From: Contact Centre (CRM) <contact@ribblevalley.gov.uk>
Sent: 25 November 2023 16:32
To: Planning
Subject: Planning Application Comments - 3/2023/0842 FS-Case-564773102

Planning Application Reference No.: 3/2023/0842

Address of Development: 8&10 Shawbridge St, Clitheroe

02 EXISTING SIDE EAST ELEVATION

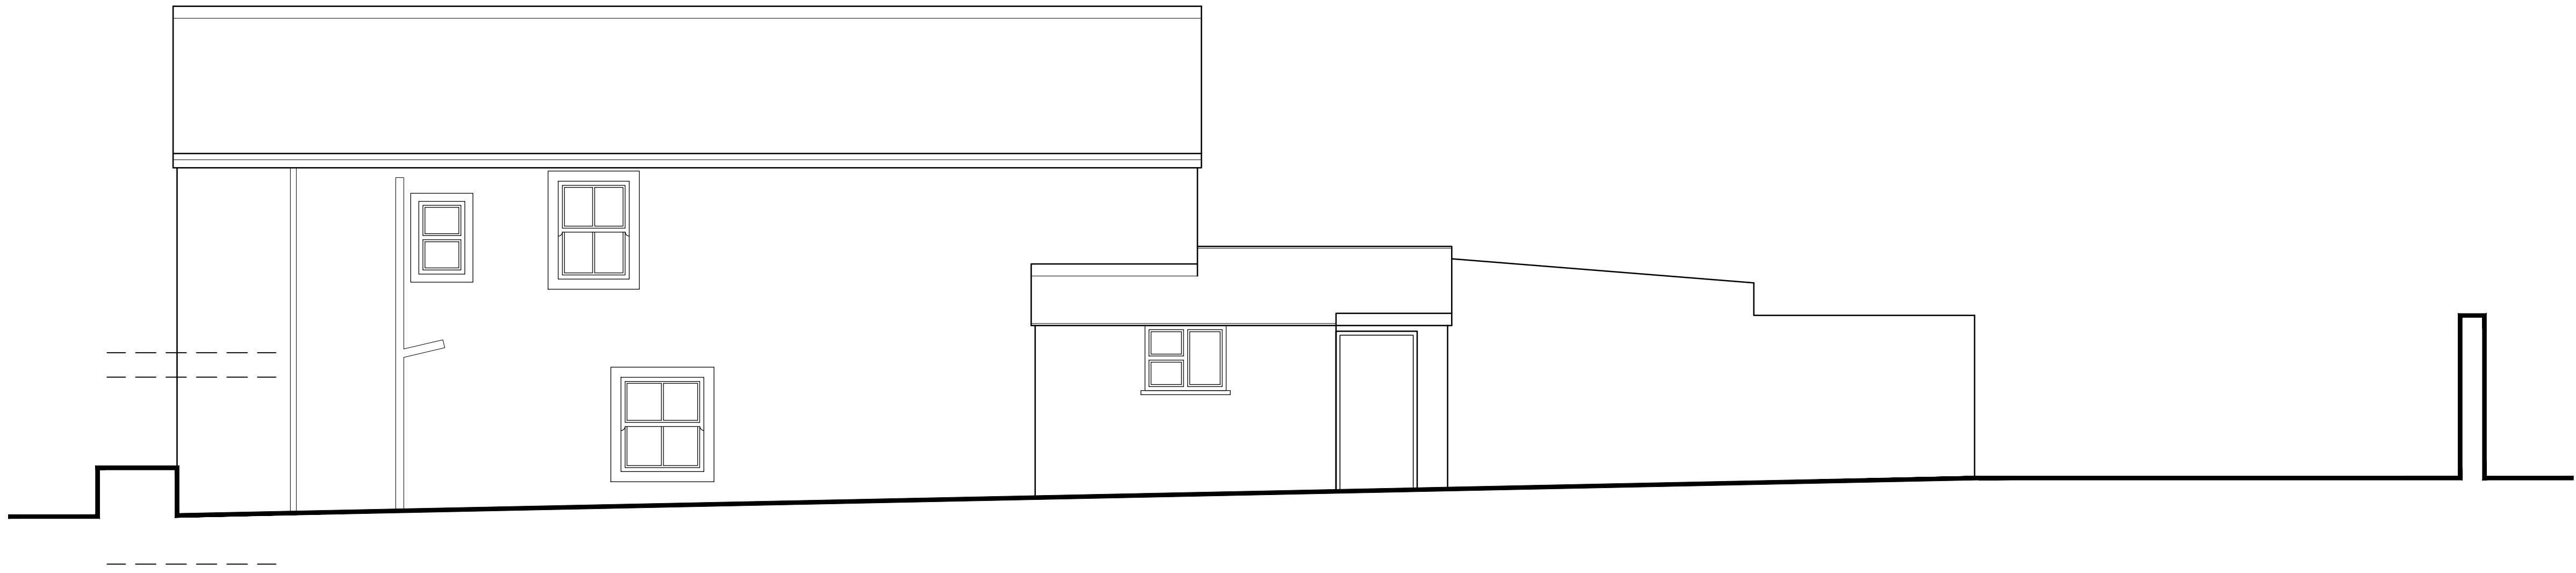
Whilst we appreciate the desire to replace the windows with double glazed units, we believe there is value in retaining what is already there on the East facing entrance. Here, the sash windows provide consistency (this is lacking in the other windows at this site) and whilst it may be difficult to determine the age of the windows on this elevation, they are complimentary to the overall appearance of the building and full consideration should be given to their retention.
